**MONUMENT FIRE DISTRICT**

To: El Paso County Planning and Community Development Department  
From: Jonathan Bradley, Fire Marshal  
Subject: Cathedral Rock Church  
Date: October 4, 2024

The Monument Fire District has reviewed the Cathedral Rock Church site development plan dated 9/27/2024. Based on our initial review of the site plan, access for fire apparatus, emergency egress, and proposed fire hydrant location, have the following comment:

**SITE PLAN**  
SCALE: 1"=40'-0"

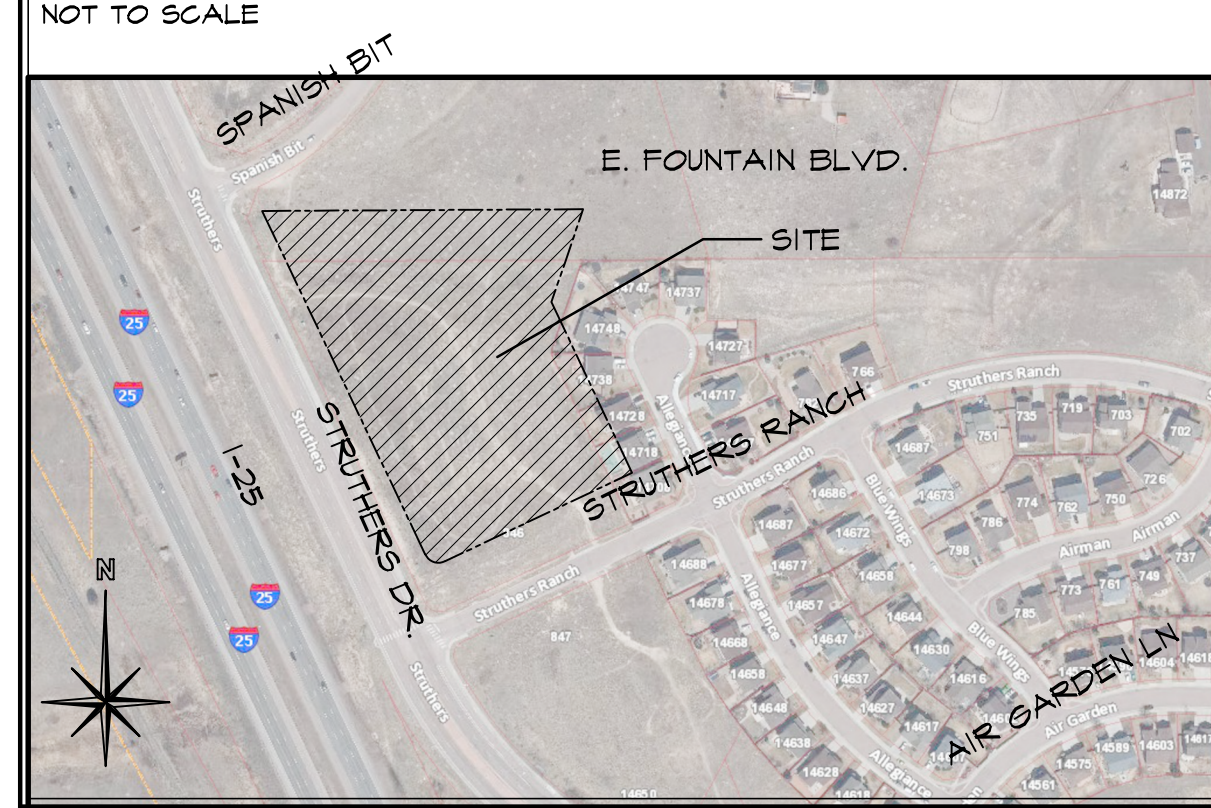
- Review 2015 International Fire Code Section 503 Fire Apparatus Access Roads, 503.1.1 Buildings and facilities specifically: *Fire apparatus access roads shall comply with the requirements of this section and shall extend to within 150 ft of all portions of the facility and all portions of the exterior wall of the first story of the building as measured by an approved route around the exterior of the building or facility.*

- Note the comments on the FD Markup copy of the site development plan regarding fire apparatus access
- Review the 2015 International Fire Code Appendix B Fire-Flow for Buildings

- Initial review requires 2000 gallons per minute.
- Review the 2015 International Fire Code Appendix C Fire Hydrant Locations and Distribution (use fire flow calculation to determine number of hydrants, location, and spacing.)

- Initial review requires at least 2 fire hydrants with average spacing of 450 ft and maximum distance from any point on the road to a hydrant of 225 ft.

- Fire hydrants are not apparent on the provided site development plan.
